**From:** Barrow Parish Council <barrowparishcouncil@gmail.com>  
**Sent:** 15 April 2020 14:27  
**To:** planning  
**Cc:** Rebecca Bowers; Nicola Hopkins  
**Subject:** FAO Rebecca Bowers: Planning Application 3/2020/0142 - Clitheroe Golf Club

### Planning Application 3/2020/0142 - Clitheroe Golf Club

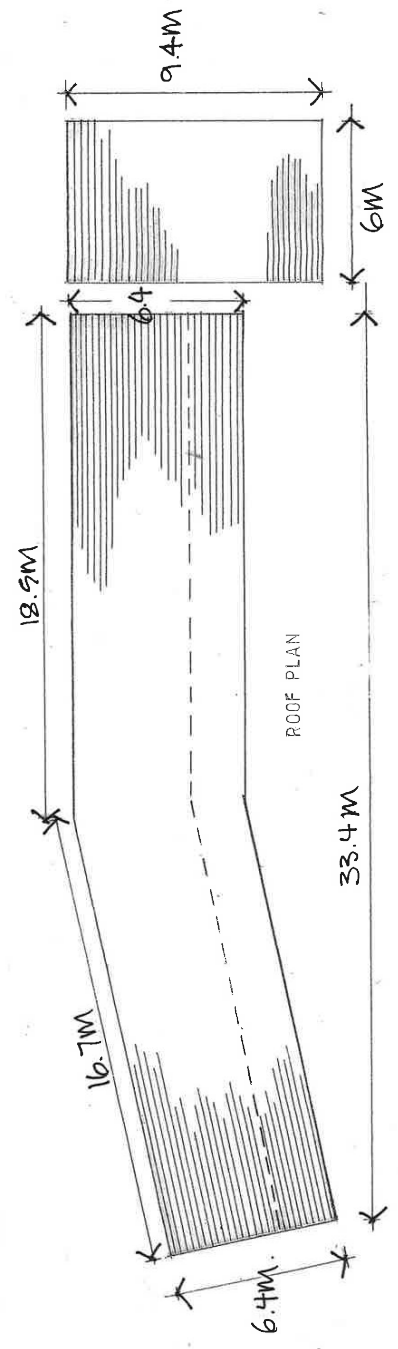
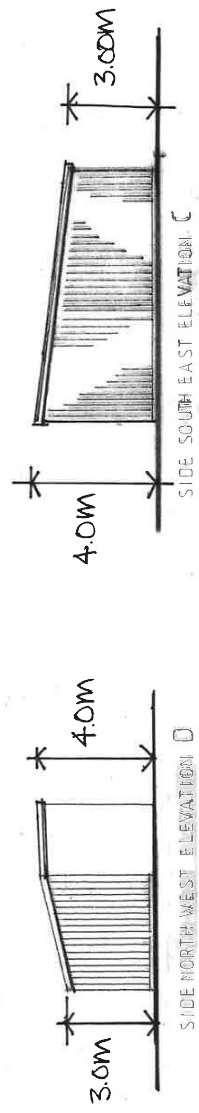
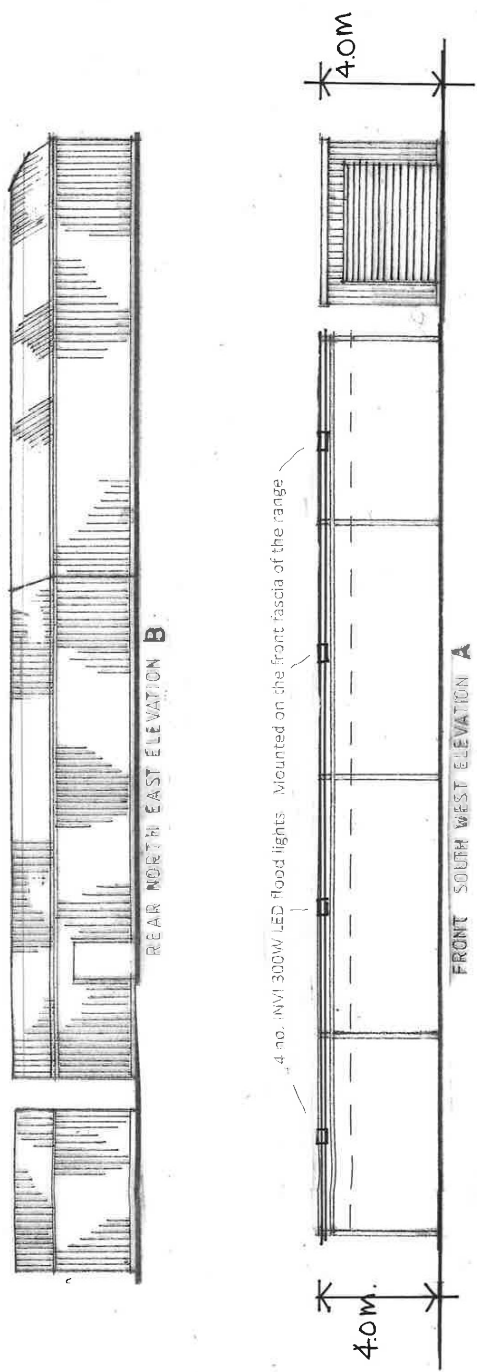
It is felt that the Golf Club has deliberately flouted the previously approved plans and conditions under reference 3/2019/0653 with the construction currently underway. The proposals are not 'fundamentally the same'. They show a change of dimensions, a change of materials and a change of location. Members wonder if this was a backdoor method to gain approval for a scheme that would not otherwise be acceptable? Members believe that the current application should NOT be given consent, but rather the original plans for a smaller, wooden structure in the approved location be reinstated. These plans are far more acceptable to its countryside location and the neighbouring properties.

Drawing Title: **SITE PLAN**

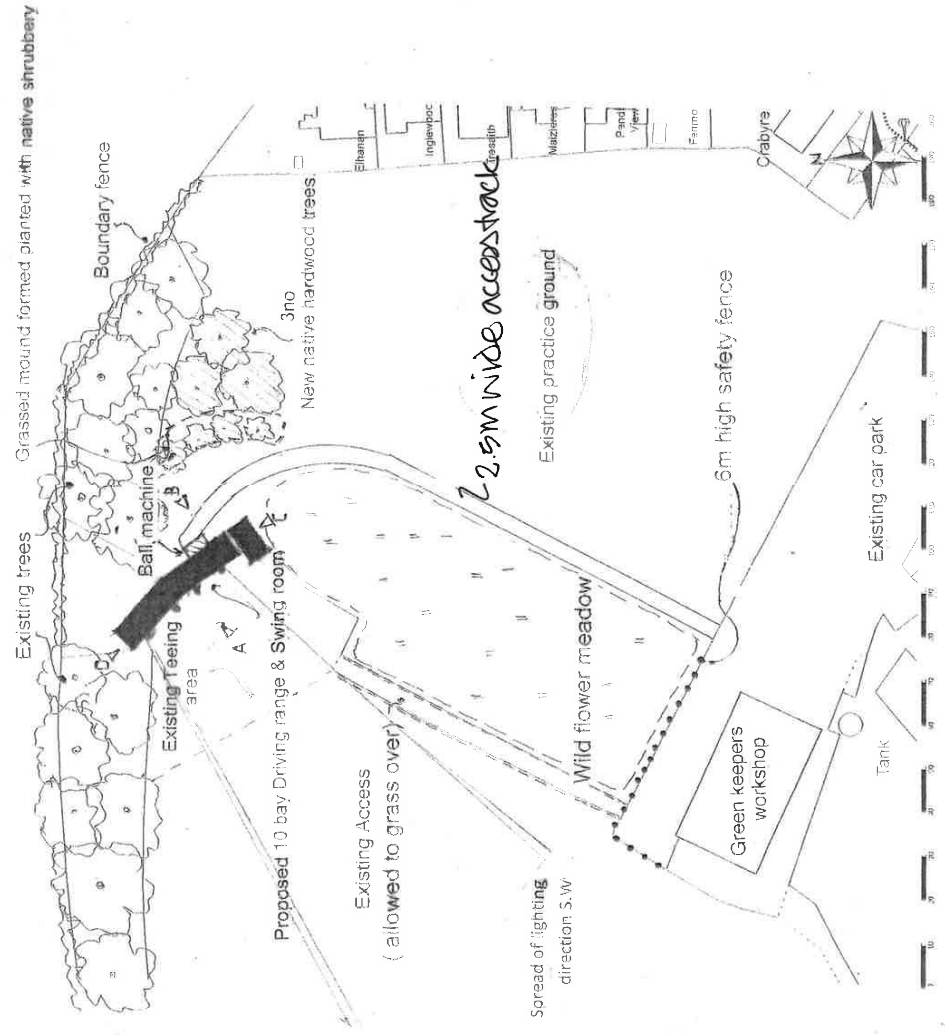
Also, it is felt that plans for the lighting design are insufficient and do not show the effect on residual lux levels at the boundary and in the vicinity of the houses, or whether it complies with the environment or accepted standards. The effect of the lighting levels on fauna in the area needs to be carefully considered as habitats for wildlife in the area are already depleted. All lighting should be at a low level, and not floodlit. Reducing the hours of operation would result in lower levels of light pollution, which would reduce the effect on wildlife and the environment.
